Our Ref: 24/00878/FUL
Your Ref: 87 High street Landbeach CB25...

**South Cambridgeshire District Council
Application for Planning Permission**

Proposal: Removal of existing asbestos garage, with new two storey rear extension including new dormer windows and replacement trees.

Site address: The Old Piano Workshop 87 High Street Landbeach Cambridgeshire

Drawing No:
AHP ACD 03 Proposed Plans and Elevations

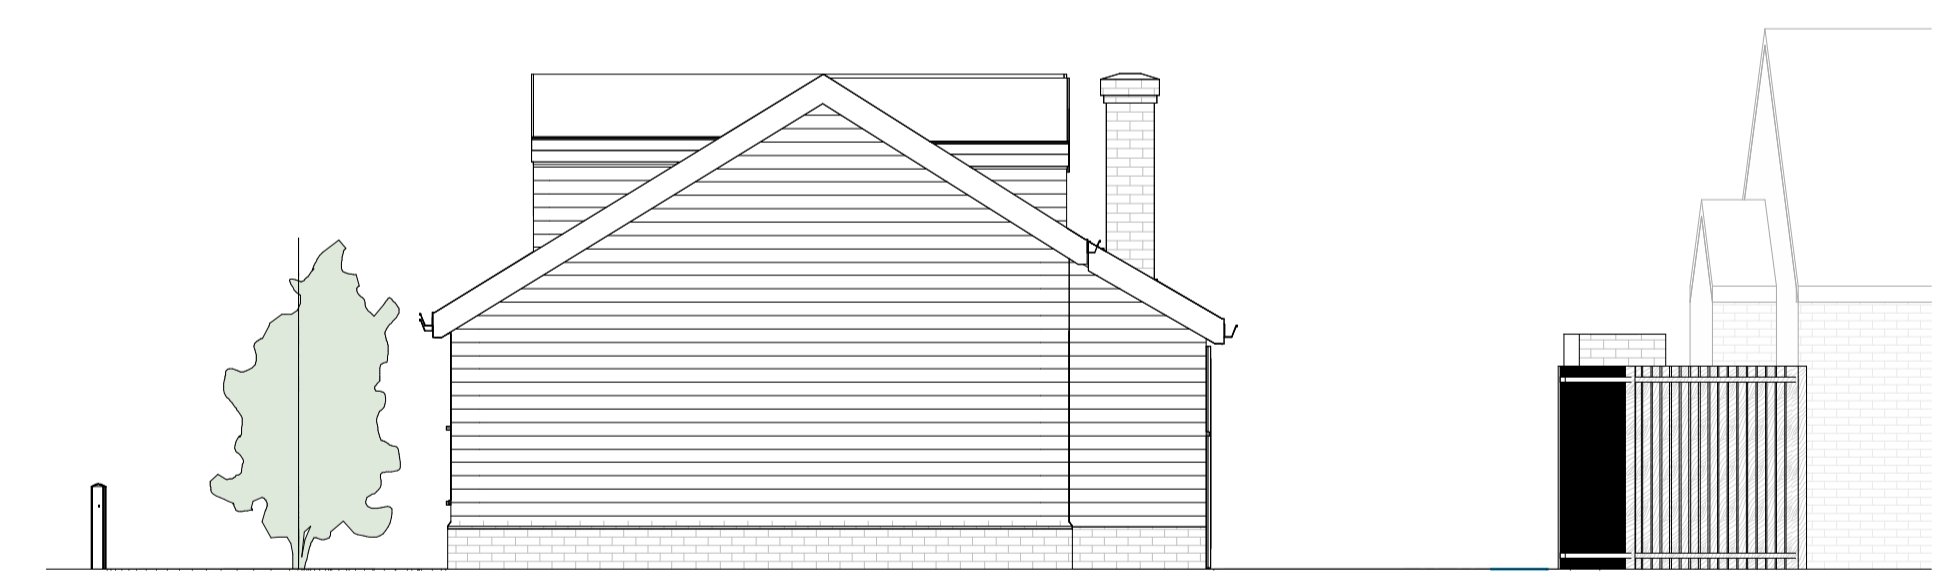
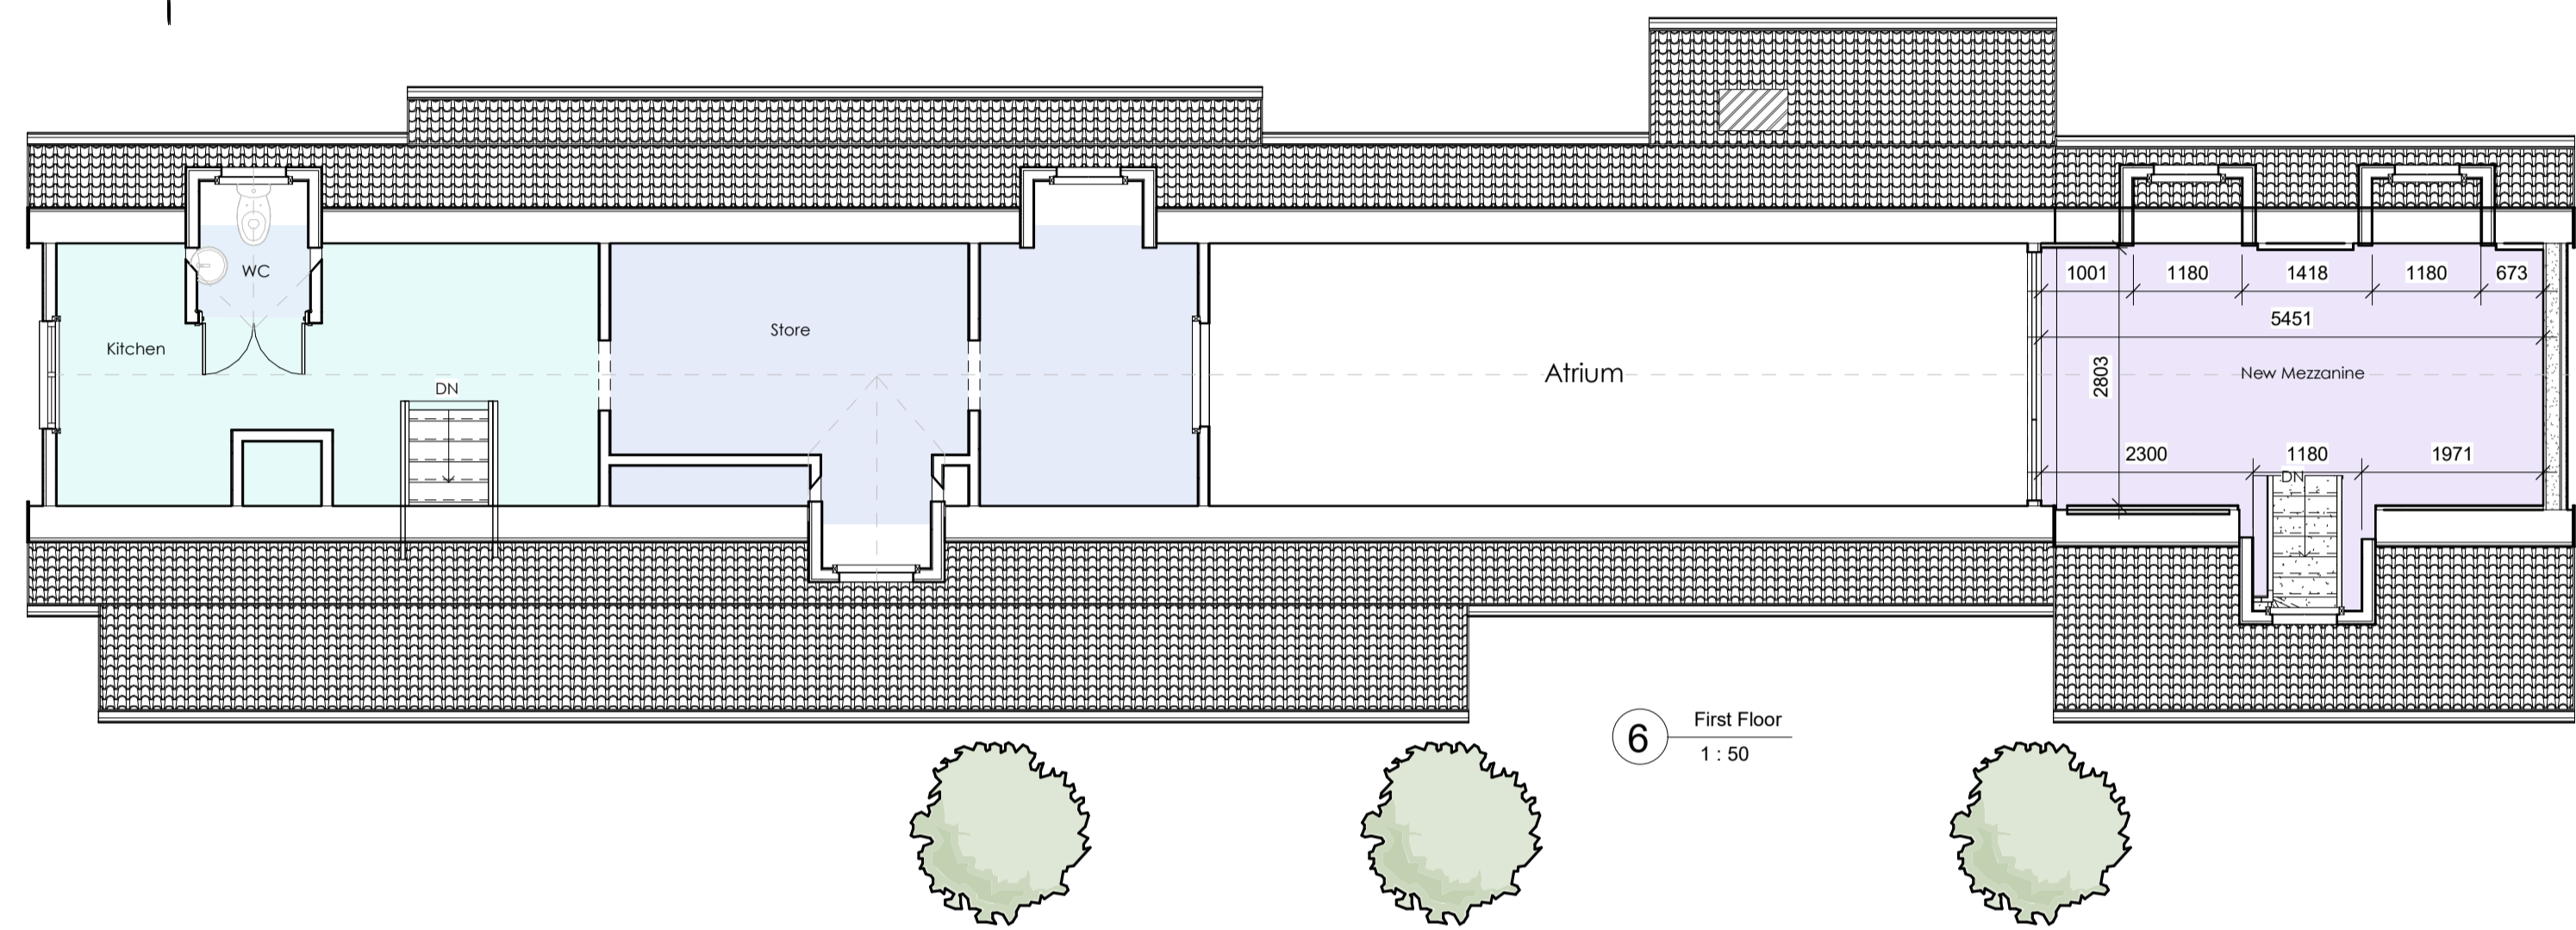
1. Please resend drawing no. AHP 03 REV01 - Proposed Plans and Elevations is not to scale, please correct and resend.
2. Please agree to the revised description of works
3. Please provide a tree survey.
